Snowy 2.0 Segment Factory, Polo Flat (SSI 10034)

Thank you for your correspondence via ePlanning portal (ref: PAE-668) on 9 October 2019, requesting Transport for NSW (TfNSW) to review and comment on the above State Significant Infrastructure Application (SSI 10034).

TAB A – Detailed Comments on State Significant Application SSI 10034

Figure 1: Map of audit location (source: Google My Maps)

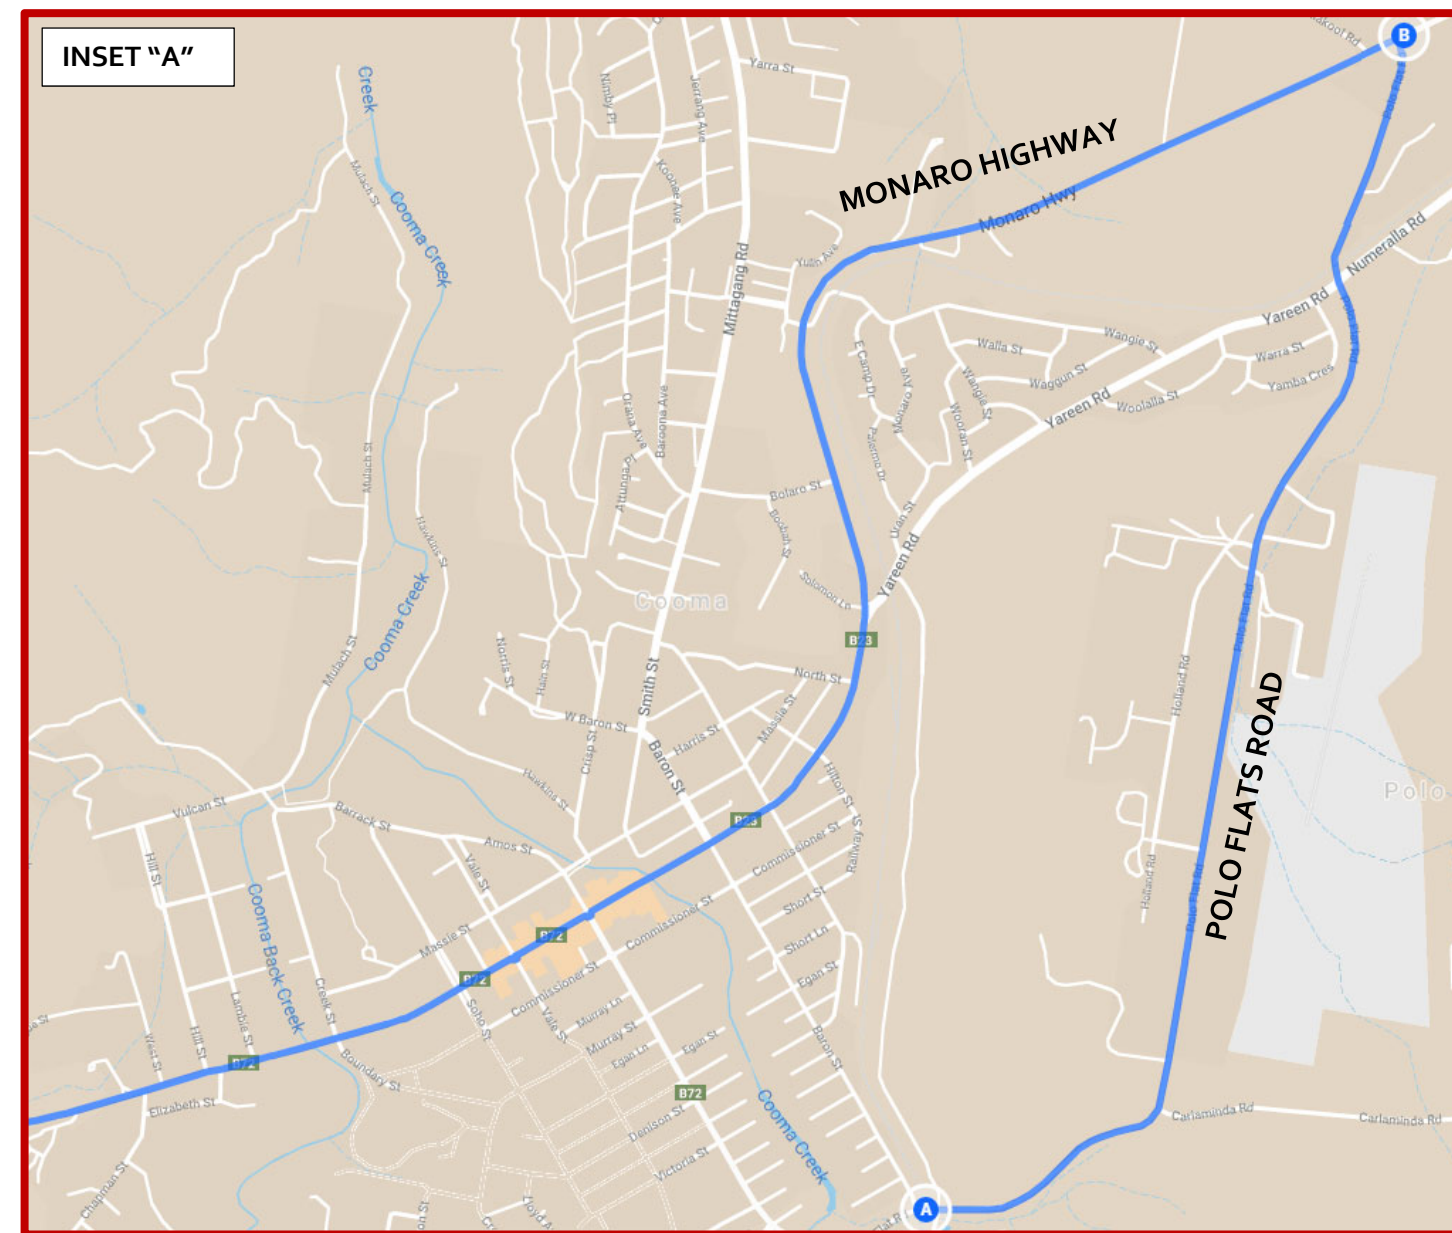
The RSA provided in the TTA recommends removing redundant signage including railway crossing signs, give way signs and reduce speed residential signs associated with the level crossing at Polo Flat Road. However, JHR is currently planning to have the rail removed on a 'temporary and long term' basis in or about November 2019 which would include the removal of the give way and level crossing sign.

The RSA provided in the TTA recommends that the rail bridge piers should be shielded with approved road safety barriers and crash cushions on either end and should be installed to an approved design. It further recommends preparing a Construction Access Management Plan (CAMP) to inform heavy vehicle drivers that vehicles must be within the vertical clearance being 4.1m of the underbridge.

It is recommended that the Proponent does not remove the signage.

The Proponent should undertake the recommended rail bridge works at their own costs and in consultation with JHR. In addition, a CAMP should be prepared, which amongst other things, informs heavy vehicle drivers that vehicles must be within the vertical clearance, being 4.1m, of the underbridge.
